PLANNING CONSULTATION RESPONSE

Application No	2026/0488
Proposal	Change of use of the first floor to create a flat with metal access steps to the rear and minor alterations to the ground floor to create a funeral directors
Address	24 High Street, Goldthorpe, Rotherham, S63 9LR
Date of Consultation Reply	23 rd July 2026
Consultee	Highways DC

Proposed First Floor Layout

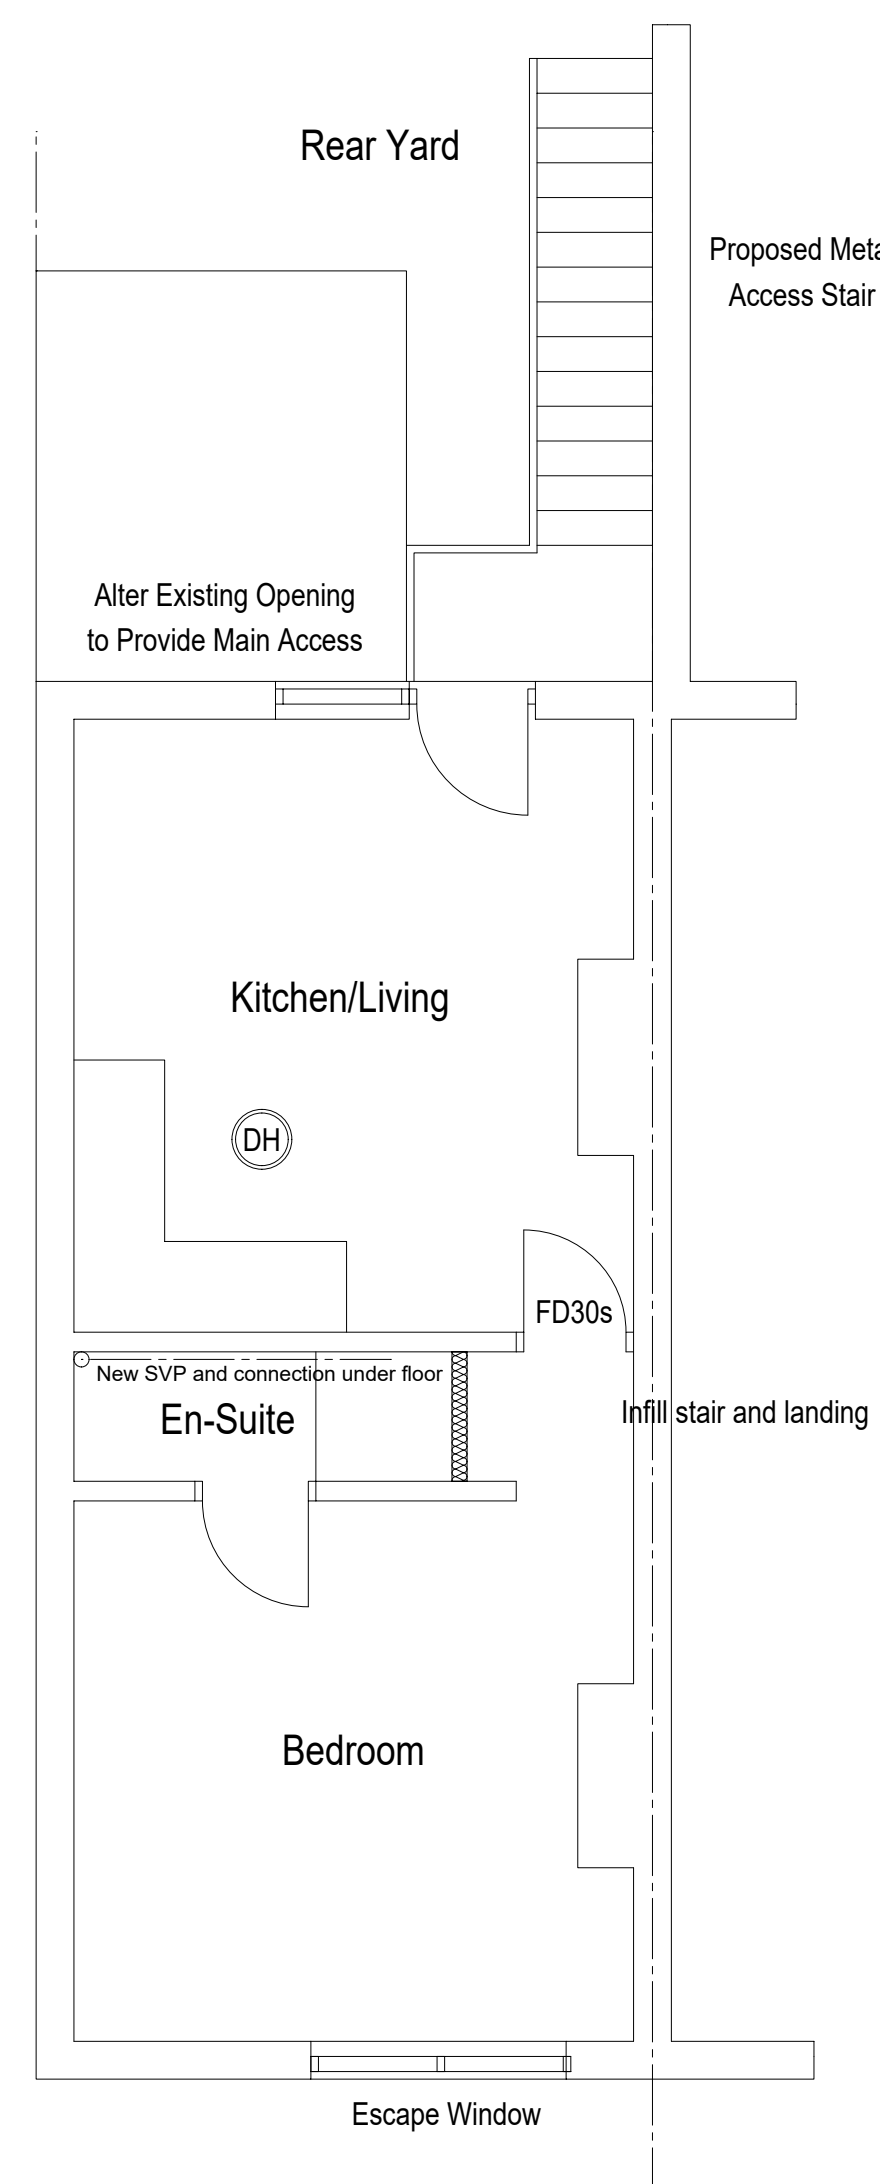
With regard to the proposed change of use of the first floor in order to create a one-bedroom flat, I would comment that, as mentioned above, the site has no off-street car parking provision and none is proposed; the Barnsley Supplementary Planning Document (SPD) Parking (2019) Table 1 states that one car parking space should be provided per 1-2 bedroom dwelling, thereby creating a shortfall of one parking space for the proposed residential use.

Notwithstanding this, the site is located within the centre of Goldthorpe and has a large number of amenities within easy reach as well as benefiting from having good access to public transport facilities. This means, subject to the provision of suitable cycle parking facilities, that the residential use of the site is considered to be sustainable and therefore compliant with NPPF 9: Promoting Sustainable Transport policies and Barnsley Local Plan (January 2019) Policy T3 New Development and Sustainable Travel.

The change of use hereby permitted shall not commence until a scheme for the parking of bicycles complying with LTN 1/20 Cycle Infrastructure Design has been submitted to and approved in writing by the LPA. The scheme shall be fully implemented before the development is first occupied (or brought into use) and thereafter retained for this purpose.
